Norfolk County Council Comments on the A47 North Tuddenham to Easton Dualling 15 June 2021

Norfolk County Council:

Supports the principle of dualling the A47 between North Tuddenham and Easton subject to:

Figure 3.2 – Proposed Wood Lane Interchange

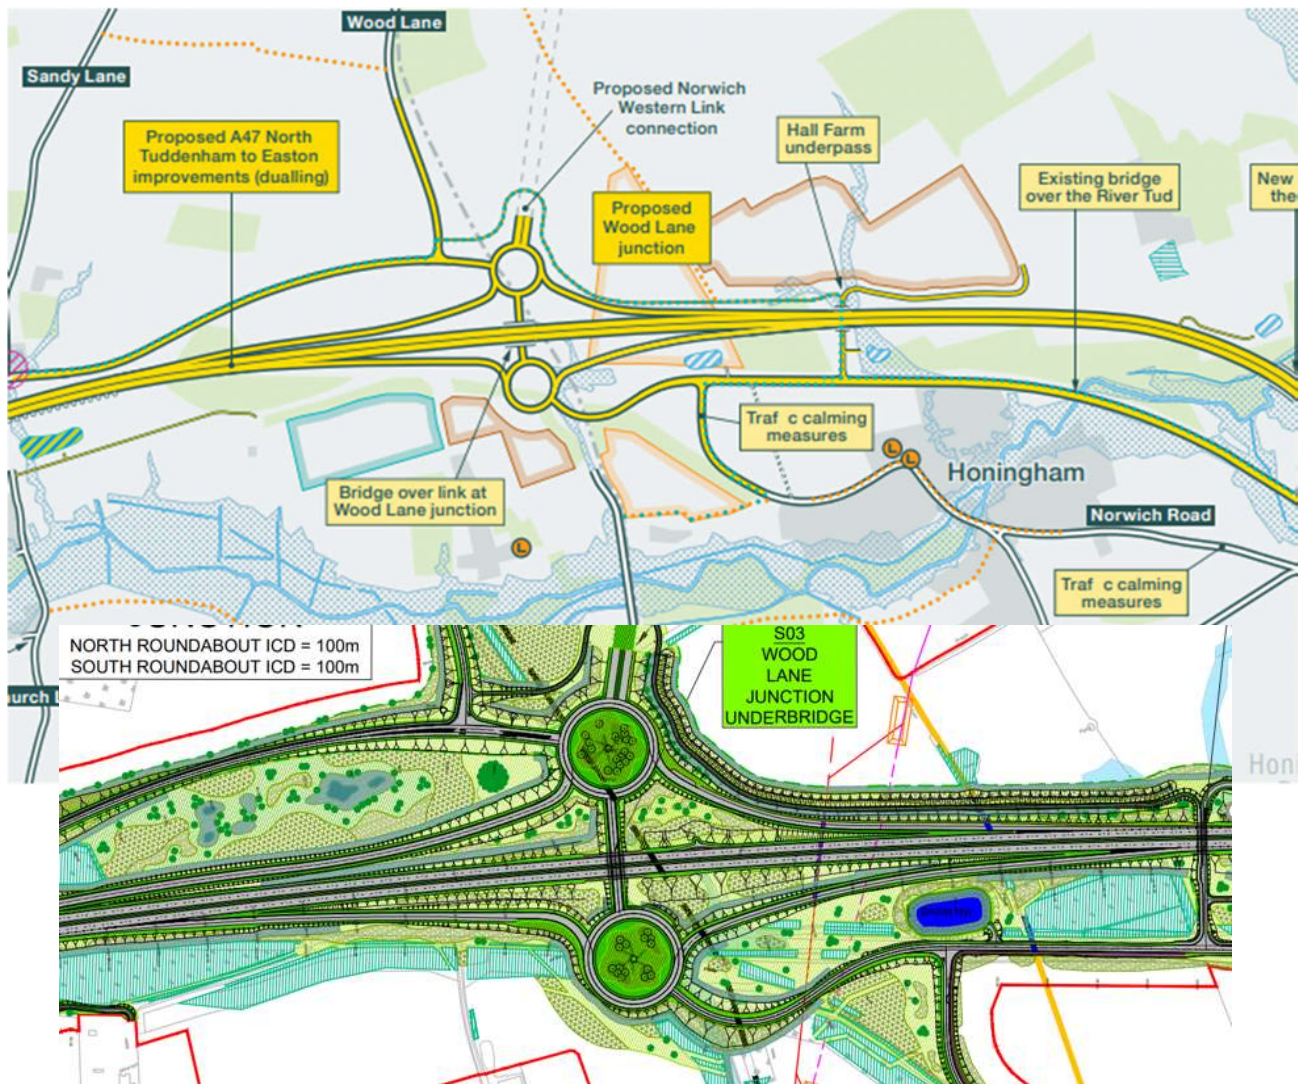
The link road between the two roundabouts at the Wood Lane junction is proposed as a single carriageway through an underpass beneath the dualled A47. Norfolk County Council has raised concerns about the capacity of this, its possible future long-term capacity and also about its resilience should there be an incident on the underpass.

This part of the network is proposed to form part of the local, non-trunk road network and future maintenance and management would fall to the county council. The county council needs to be assured that its design can accommodate future traffic flows (as it is through an underpass it would be difficult / expensive to widen in the future) and that the network can be properly managed in the event of any incidents occurring in the underpass.
